**WELWYN HATFIELD ACCESS GROUP**  
 THE COMMON ROOM  
 GROUND FLOOR  
 LEY HOUSE  
 LONG LEY  
 WELWYN GARDEN CITY  
 HERTFORDSHIRE AL7 2EX

**re: Planning Applications Received by Welwyn Hatfield Borough Council**

Application No.	Description and Location	Applicant/Agent
6/2016/1007/FULL	Alterations to external appearance to include, replacement entrance door and installation of new bollards and signage  KFC Comet Way Hatfield AL10 9TF	Ms J Edwards Hone Edwards Associates Second Floor Millars Three Southmill Road Bishops Stortford CM23 3DH

## WELWYN HATFIELD ACCESS GROUP'S RESPONSE TO PLANNING APPLICATION 6/2016/1007/FULL

**existing elevation F**  
scale - 1:50 @ A1 / 1:100 @ A3

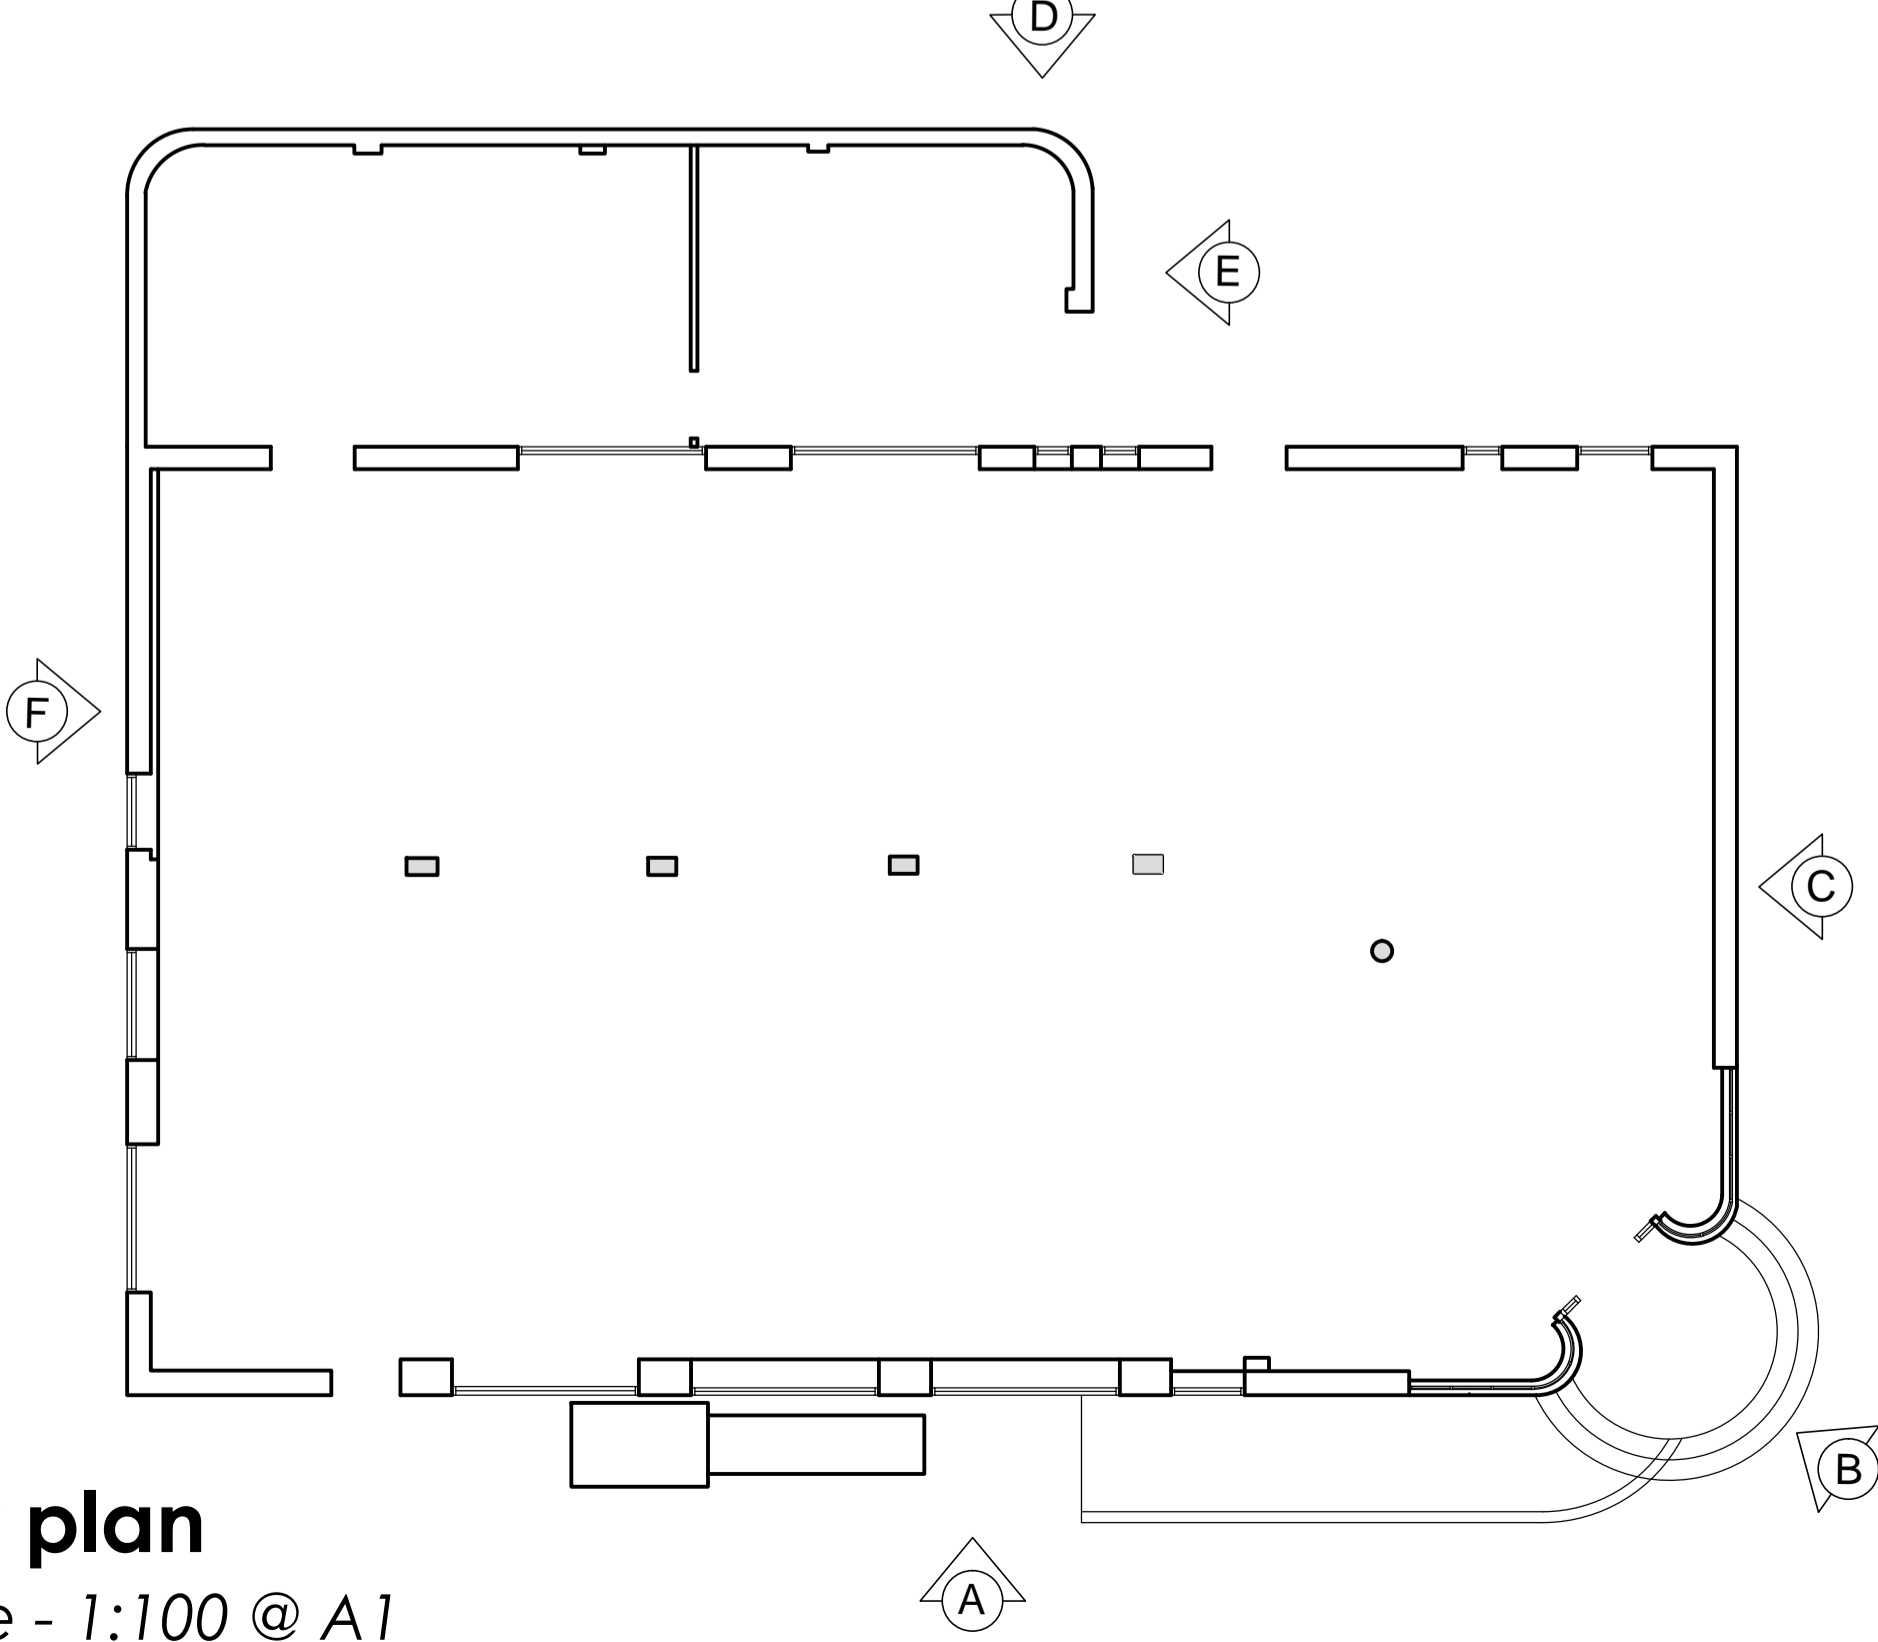
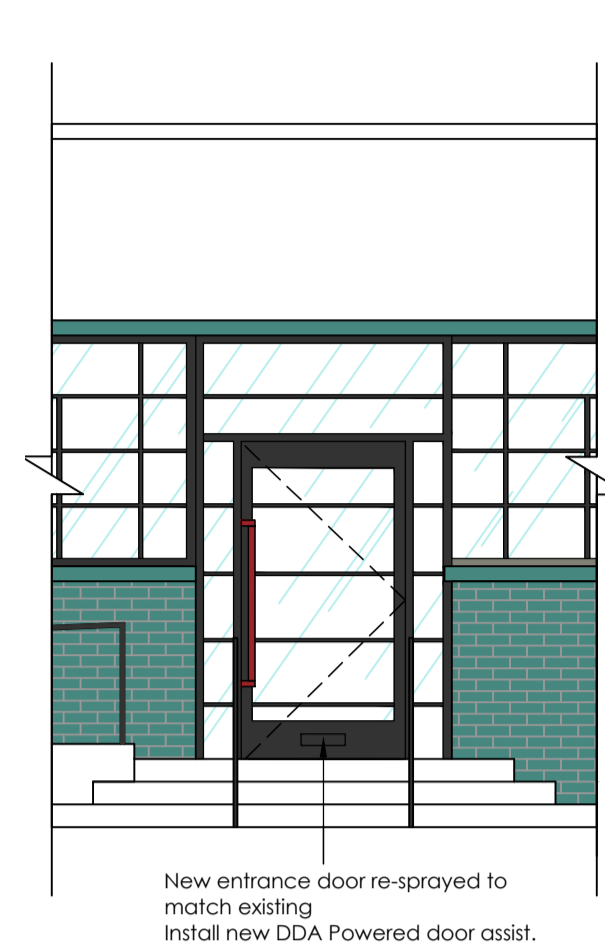
<b>DRAWIONG NO. 2542/G211 – PROPOSED ELEVATIONS</b>			We note the details outlined on this drawing.	<ol style="list-style-type: none"> <li>5 This confirms the installation of a new DDA Powered door assist. Does this make it automatic opening? We ask this because vertical offset door pull handles are specified which suggests manual opening.</li> </ol>
<b>DRAWIONG NO. 2542/G121 – PROPOSED SITE PLAN</b>			We note the details outlined on this drawing.	<ol style="list-style-type: none"> <li>6 This shows the provision of 2 disabled parking bays. What is the maximum travel distance from these to the front entrance?</li> </ol>
